**RE: Administrative Amendment justification letter
Proposed SWMD Maintenance & Administration Buildings Project, COA Project No. 7006.92
4600 Edith Boulevard NE (SE corner of Edith and Comanche)
ZONE ATLAS PAGE: G-15-Z
DRB Case SI-2019-00032**

- Development Review Application
- Form P3
- Official Notice of Decision
- Original approved Site Plan
- Original approved wall elevations
- Revised Site Plan with the above changes clouded
- Revised wall elevations
- Zone Atlas map with site outlined and labeled

SCREEN WALL ELEVATIONS

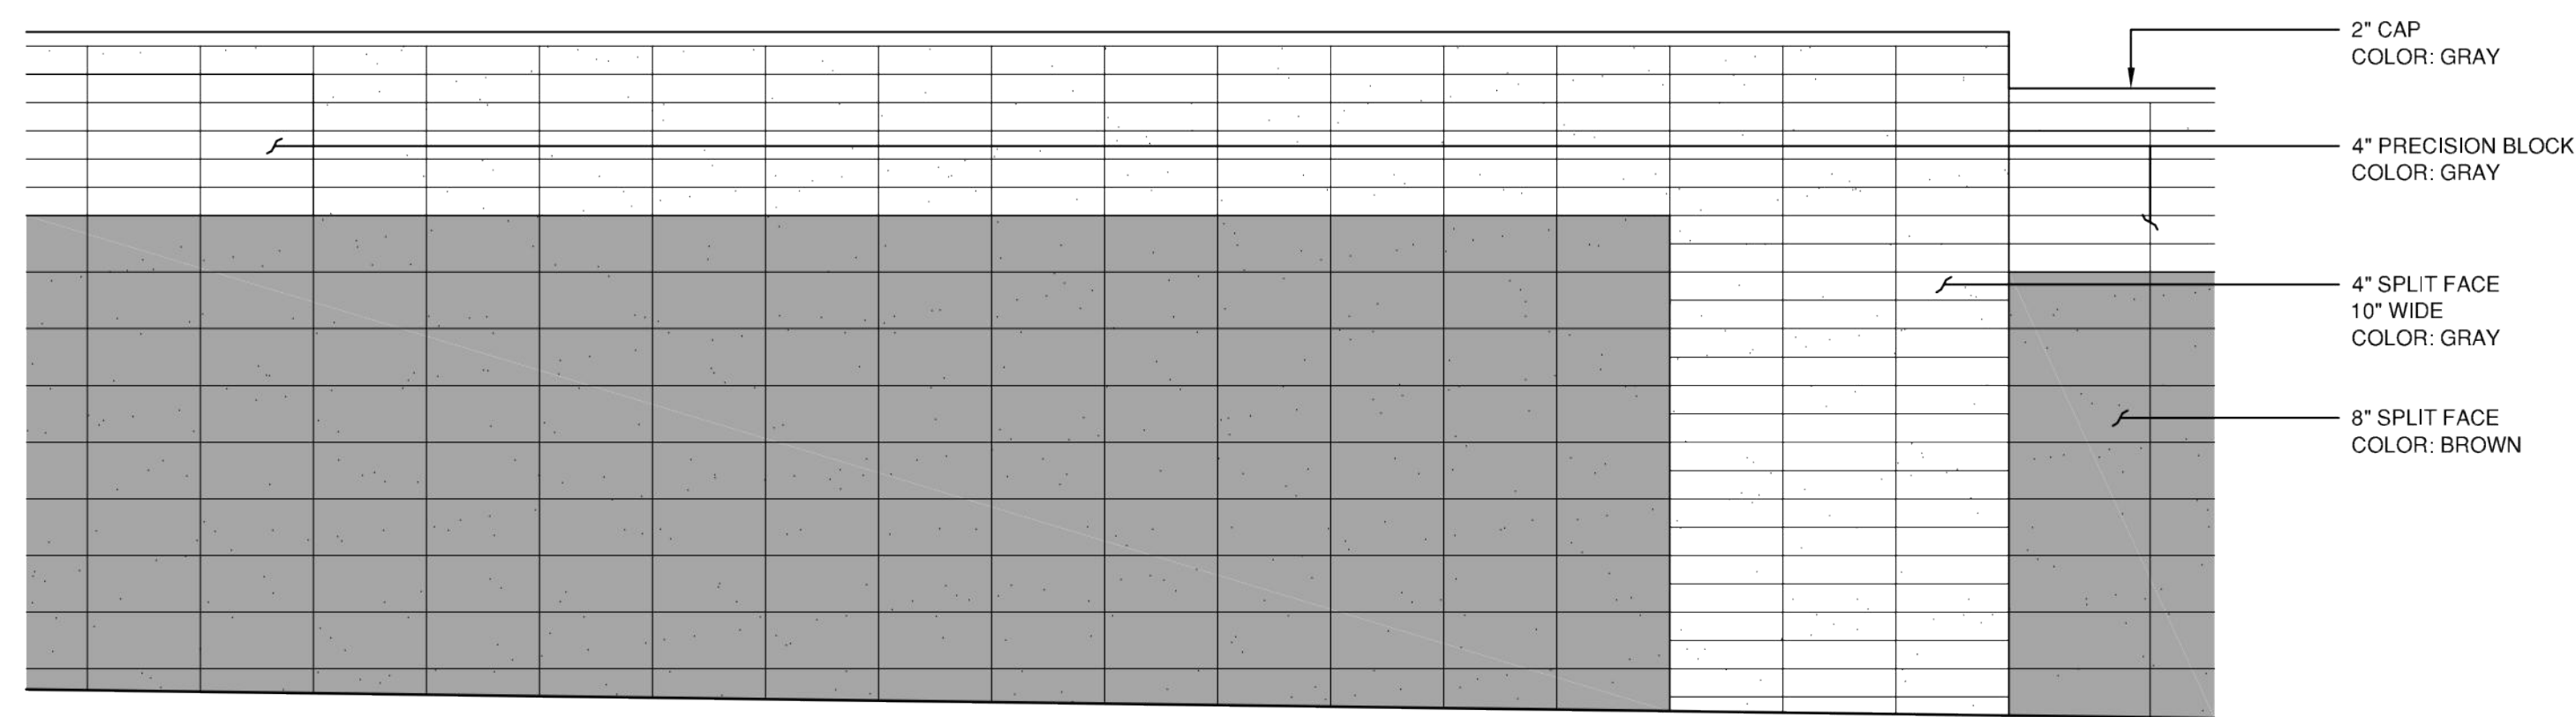
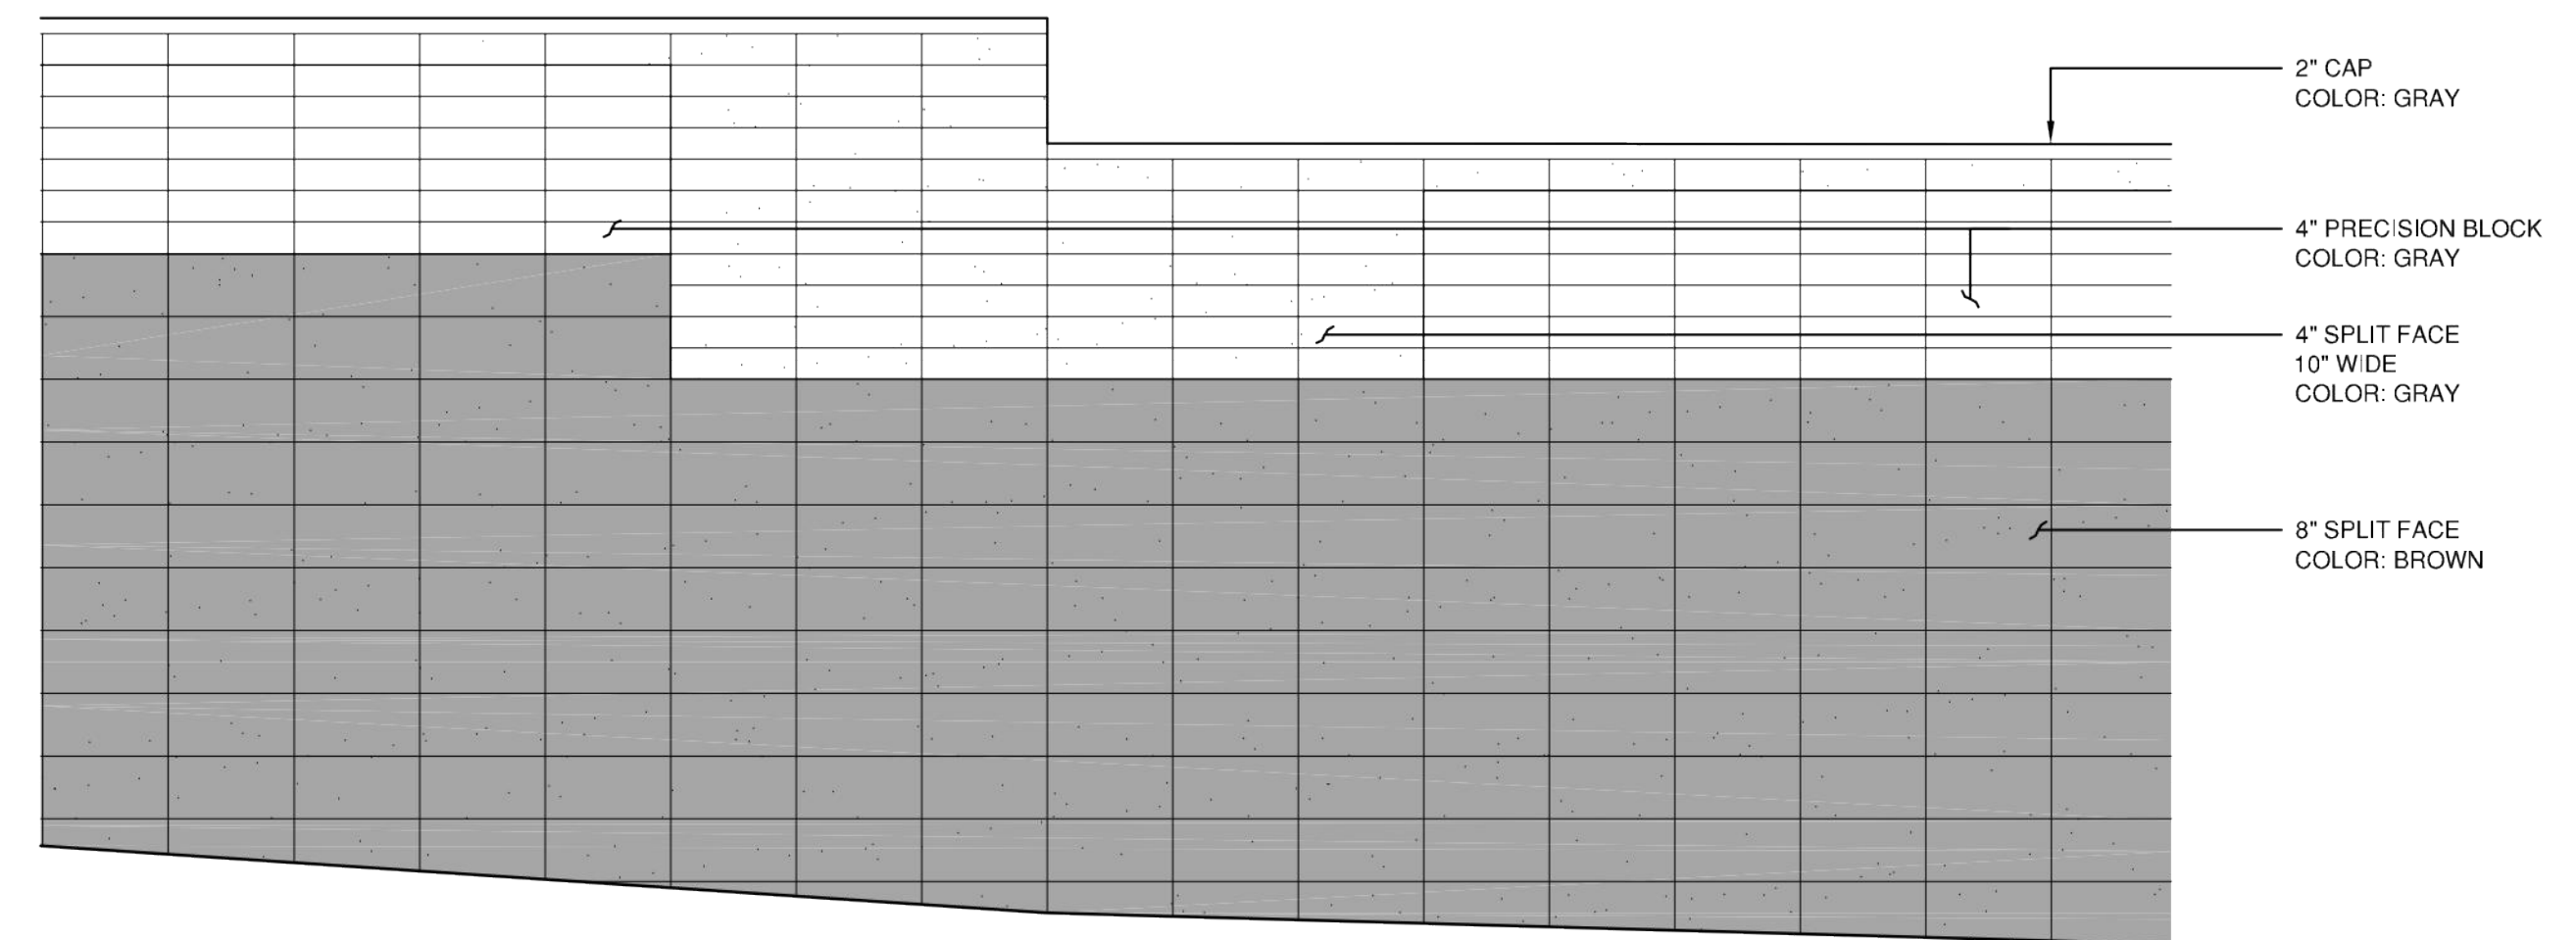
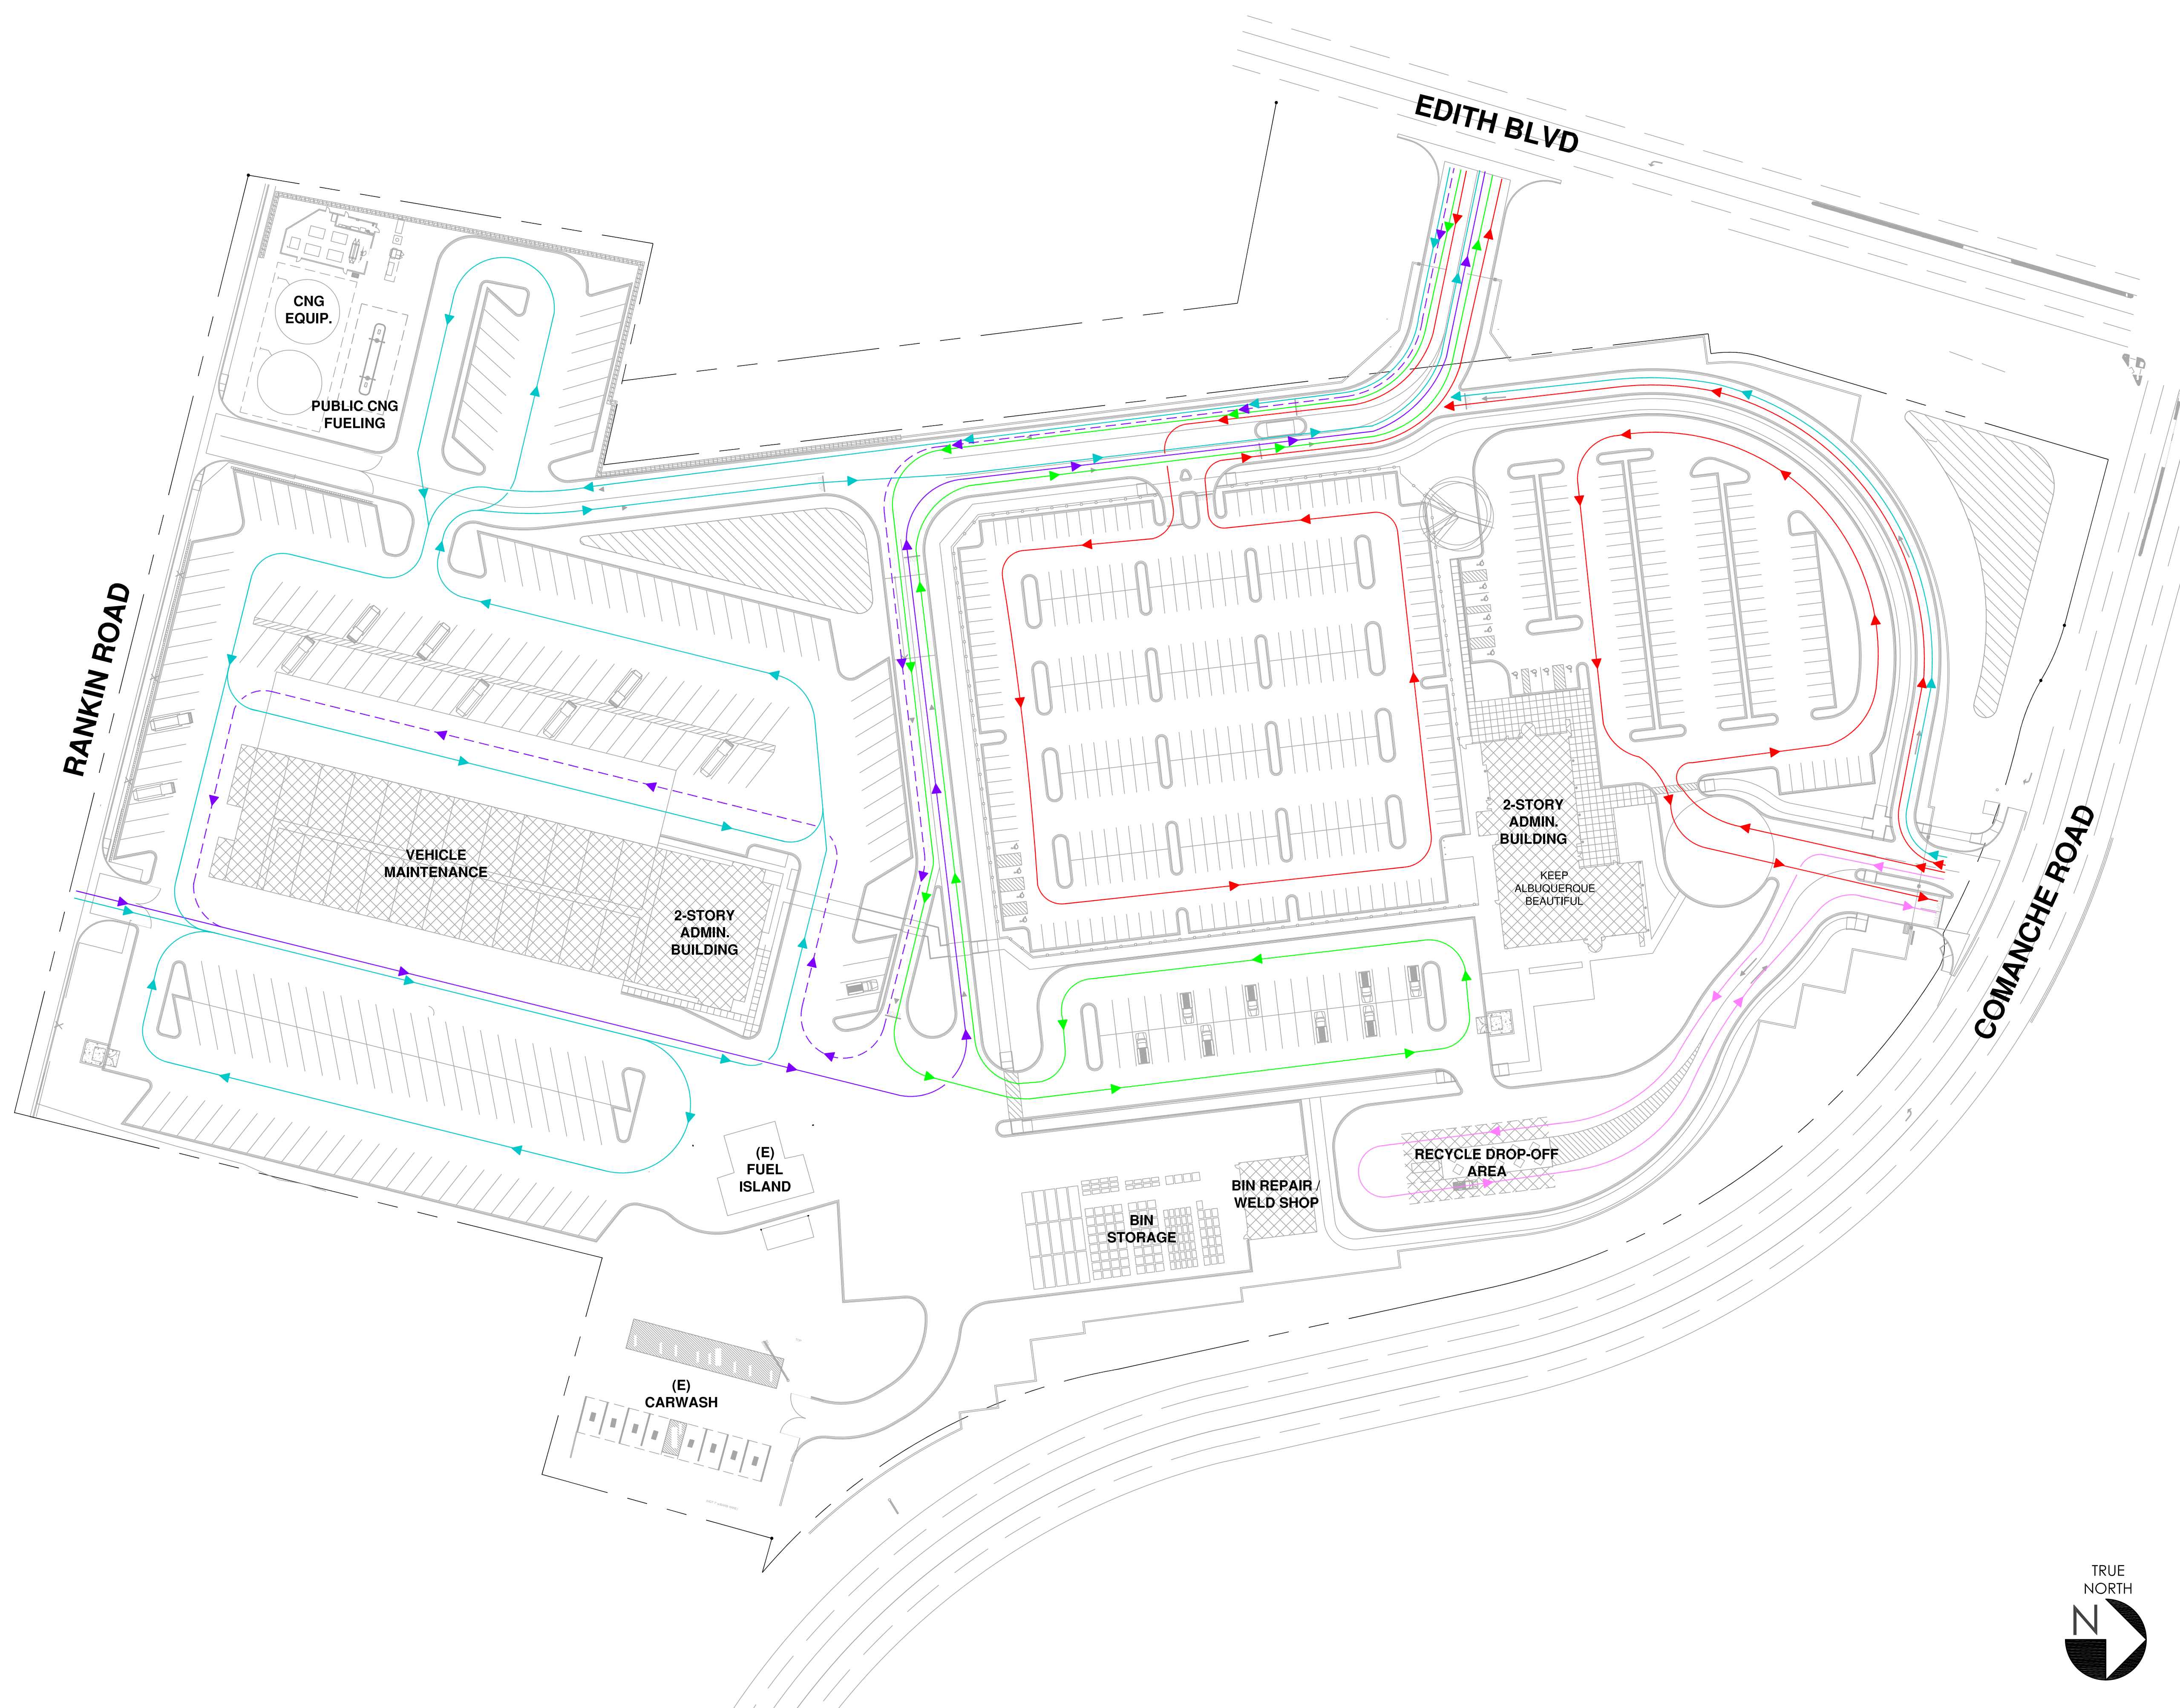
- 1. Retaining wall 02 located along Rankin Rd between the east and west entrances to the site.**
 - a. Wall material change. The wall material has been changed from CMU block to a modular block wall. Each block is much larger than a CMU block and has a rock facing. See the attached elevations for material information.
